Your ref:
Our ref: 22/01762/F
Please ask for: Miss Joanne Wren
Direct dial: 01553 616233
E-mail: borough.planning@west-norfolk.gov.uk

4 October 2022

Details: **Extension to the existing agricultural building, rainwater harvesting tank and an extended concrete apron around the tank and extension, including vehicle access tracks into the building. The proposals also include landscaping features such as grassed areas and trees planting in order to improve the appearance of the site and provide screening at Hill Farm Boughton Long Road Barton Bendish King's Lynn Norfolk**

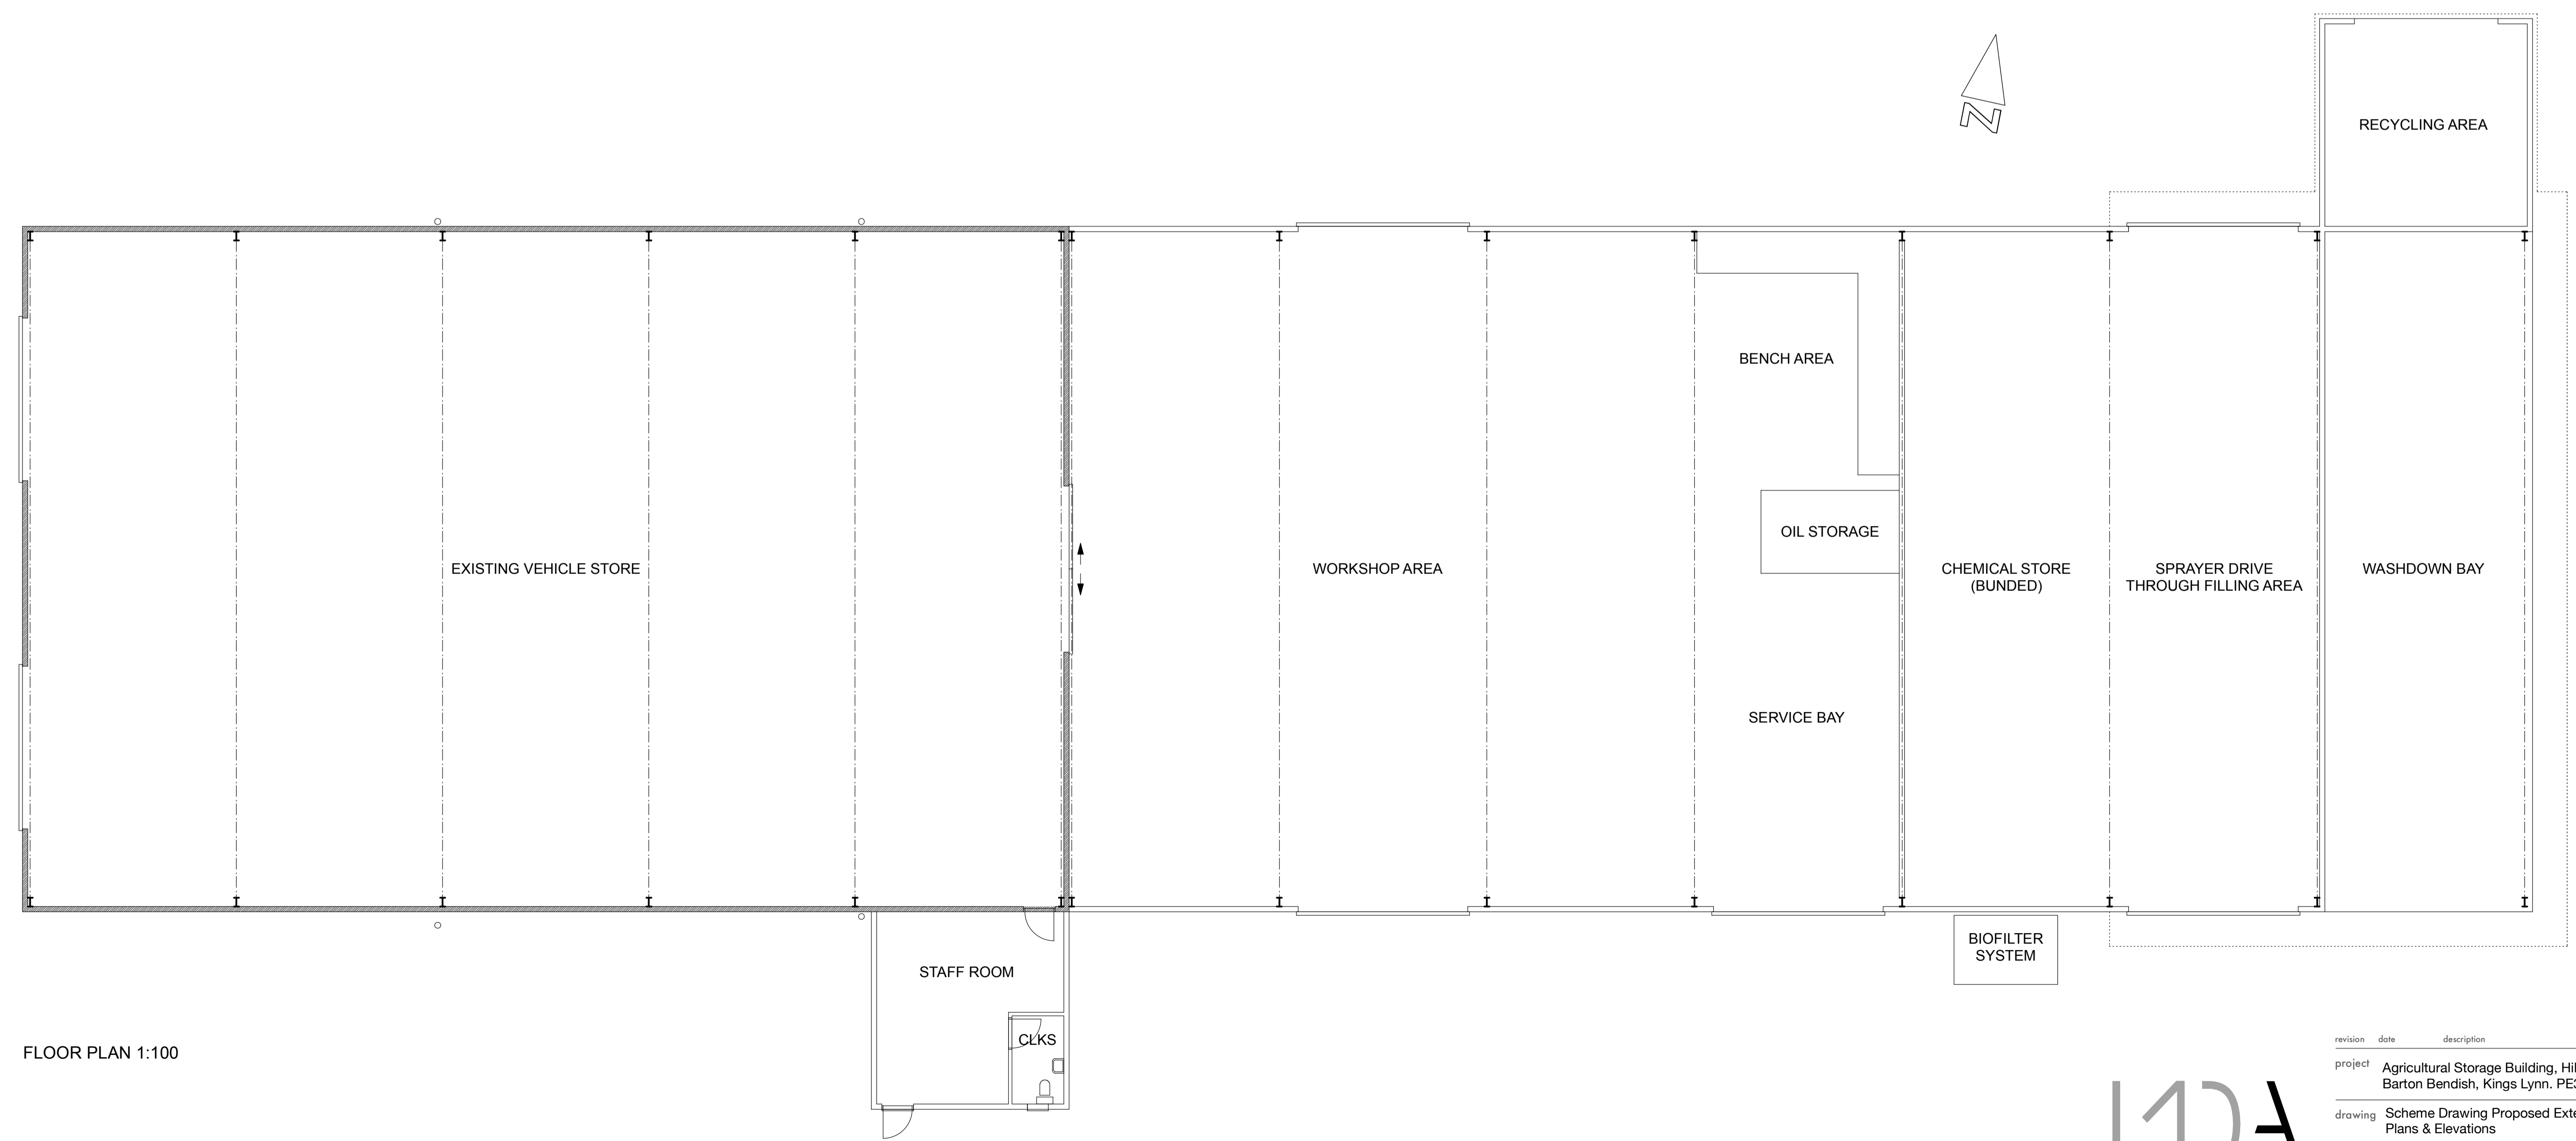
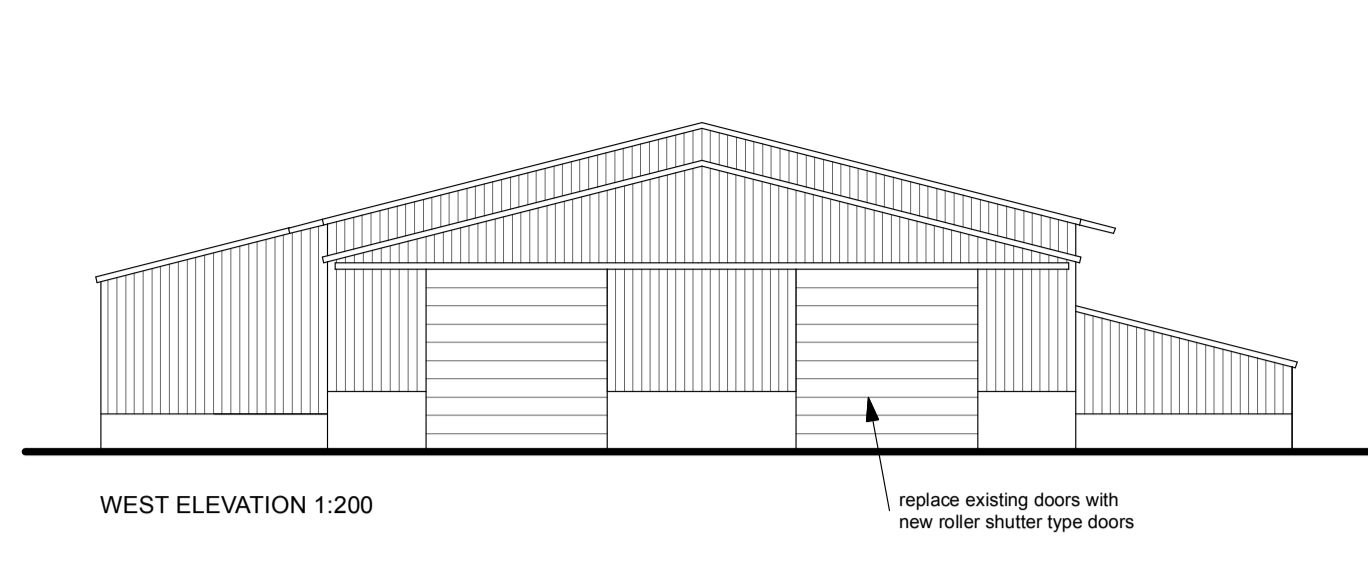
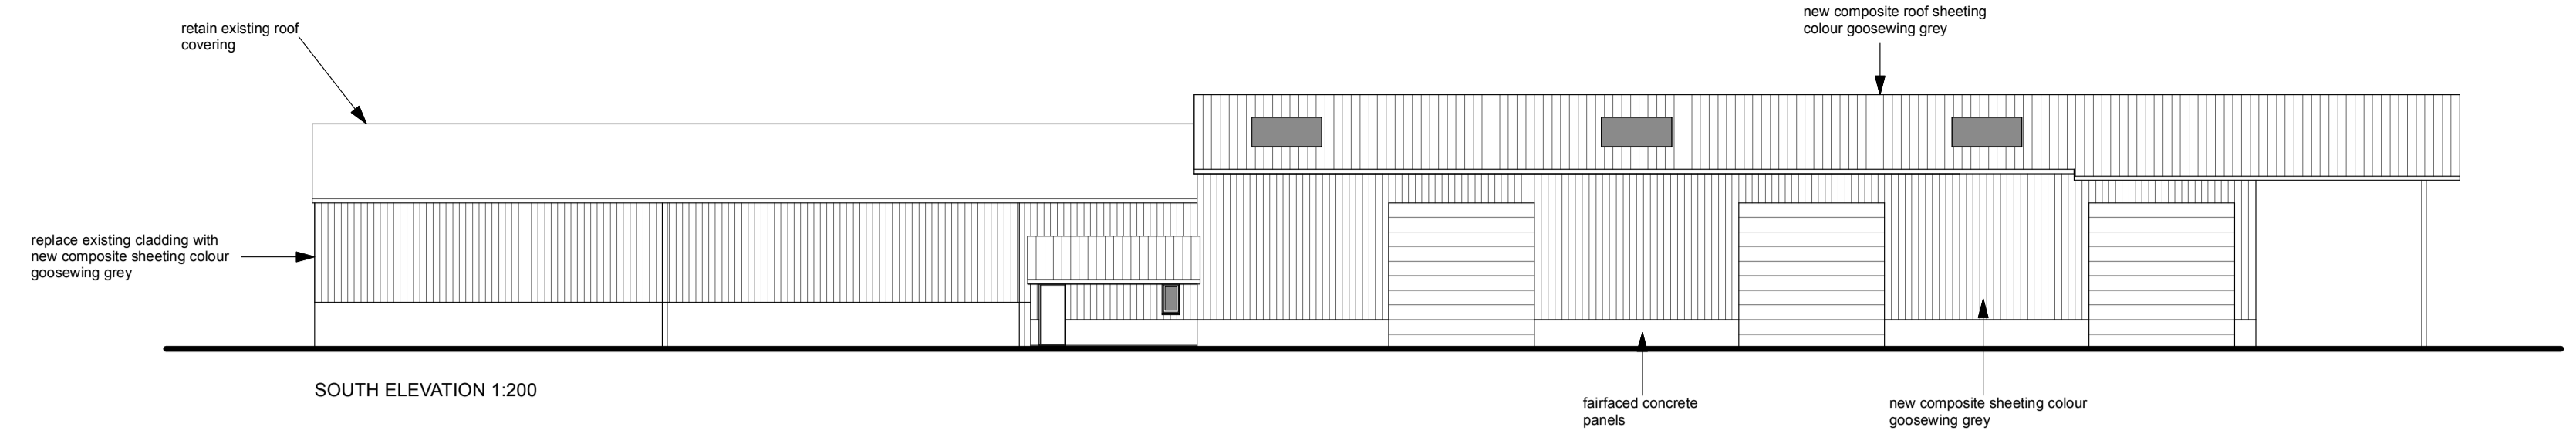
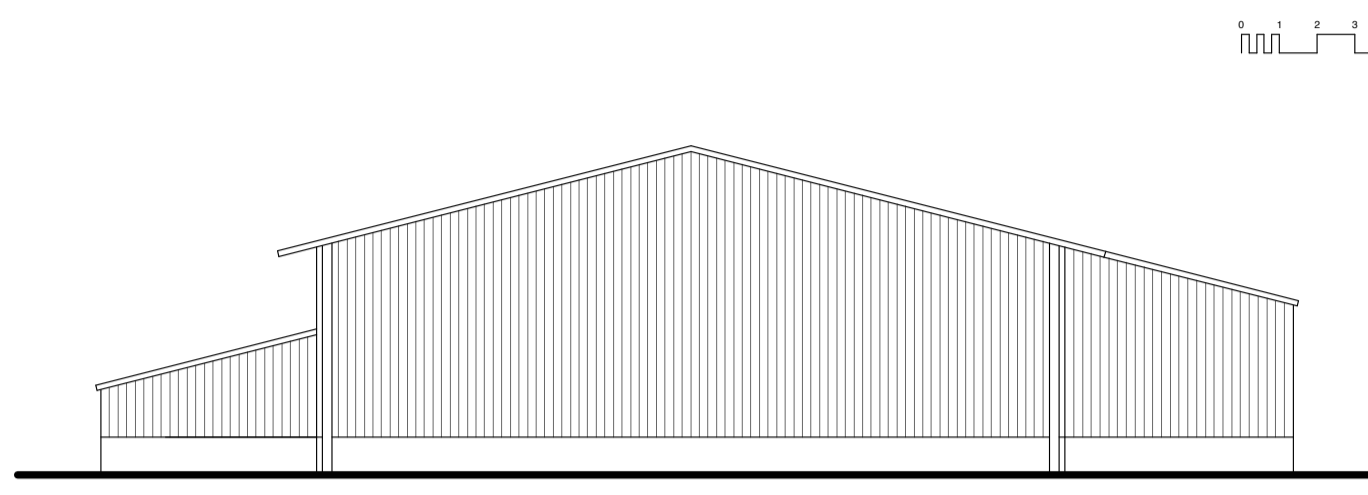
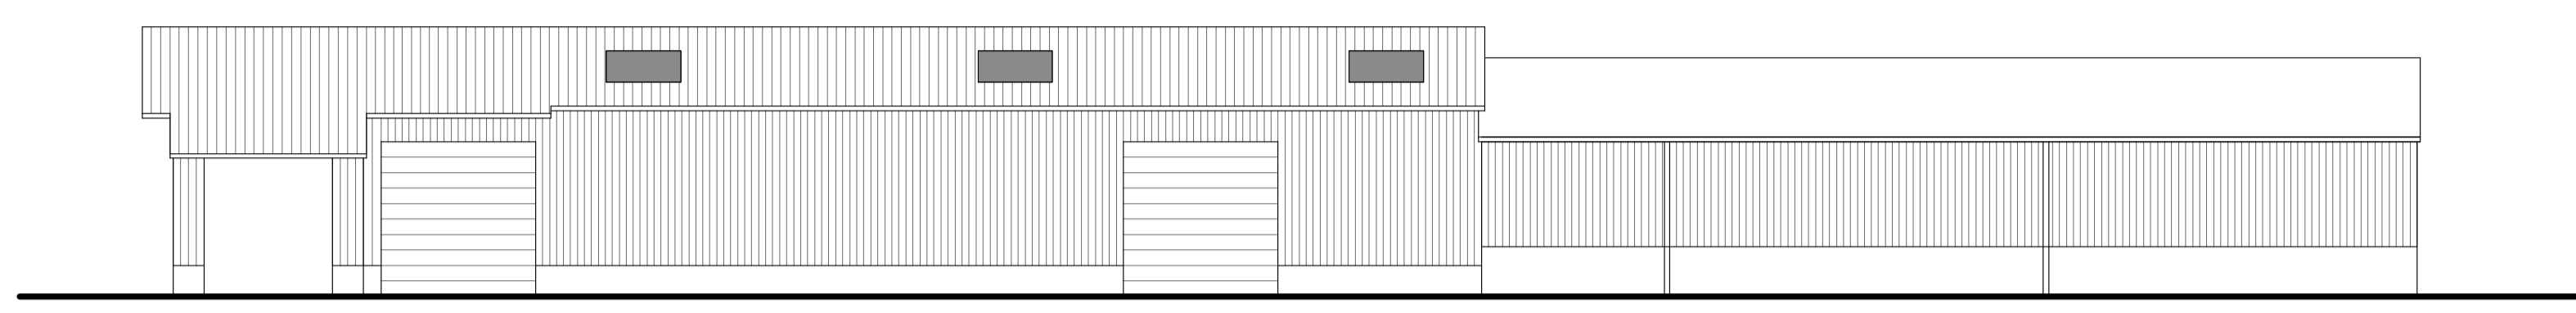
1. Thank you for submitting a drawing (no 1) showing a floor plan and elevations but we require two sets of floor plans and elevations labelled as 'existing' and 'proposed'. Please submit existing and proposed floor plans and elevations done to a scale of 1:50 or 1:100.
2. Thank you for your payment of £2310.

6. Please submit a roof plan, this should be done to a scale of 1:50 or 1:100. Please also show the roof lights on your floor plan.
